Our Ref: L01599101
28 August 2026

**Arrangements for Handling Heritage Applications Direction 2021 & Planning
(Listed Buildings and Conservation Areas) Regulations 1990**

**Seas End Hall, Hall Lane, Moulton Seas End, Lincolnshire, PE12 6LB
Application No. H13-0876-25**

DRAWING TITLE
Proposed Elevations Of
Coach House

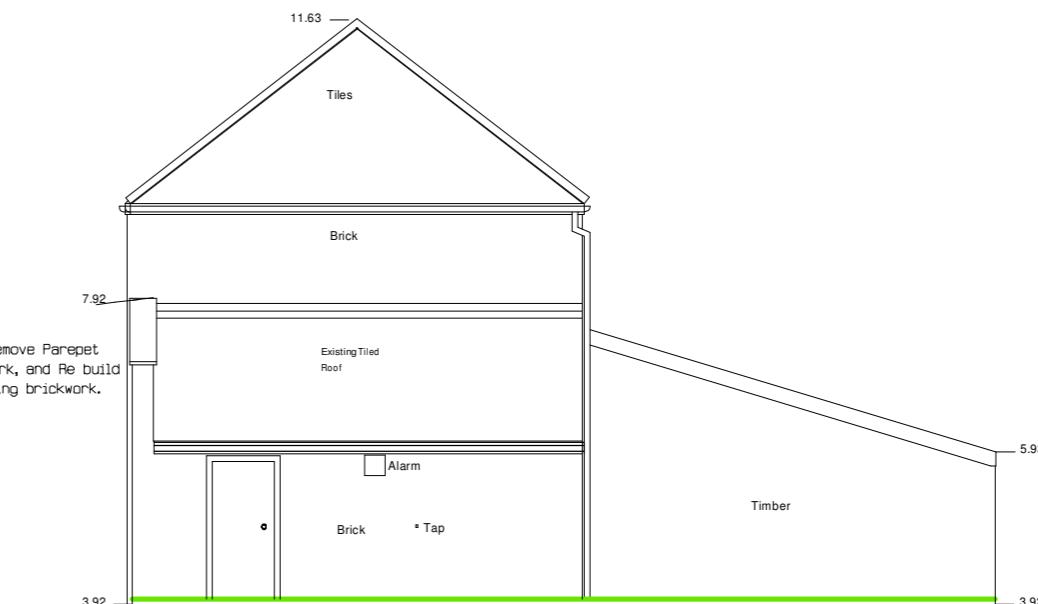
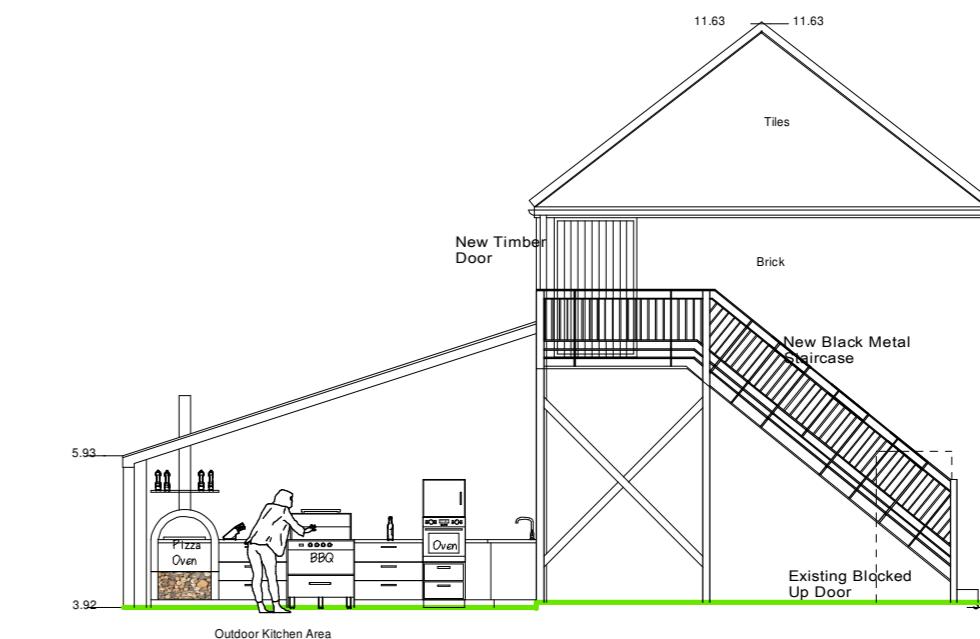
We previously recommended that historical research is undertaken to understand the evolution of the coach house to inform proposed changes to the façade. This has not been provided, therefore we assume that the proposed window design is not informed by any historic evidence and as such is not appropriate.

The application proposes a very large domestic-style window to the first floor, the full width of the carriage doors below. The large window would visually compete with the carriage doors below and would represent a fundamental change in the building's character, causing harm to significance.

The façade of the Coach House is close to, and highly visible in views of, the Grade II listed Seasend Hall. Therefore, the window has the potential to impact the setting of the main hall. The proposed window appears to be larger than the sashes of the main house (although note that scale is not available). This is highly irregular for an ancillary building of this type and would disrupt the natural hierarchy of buildings, causing harm to their significance.

We encourage the exploration of other more subtle alternatives such as breaking up the glazing mass into smaller windows.
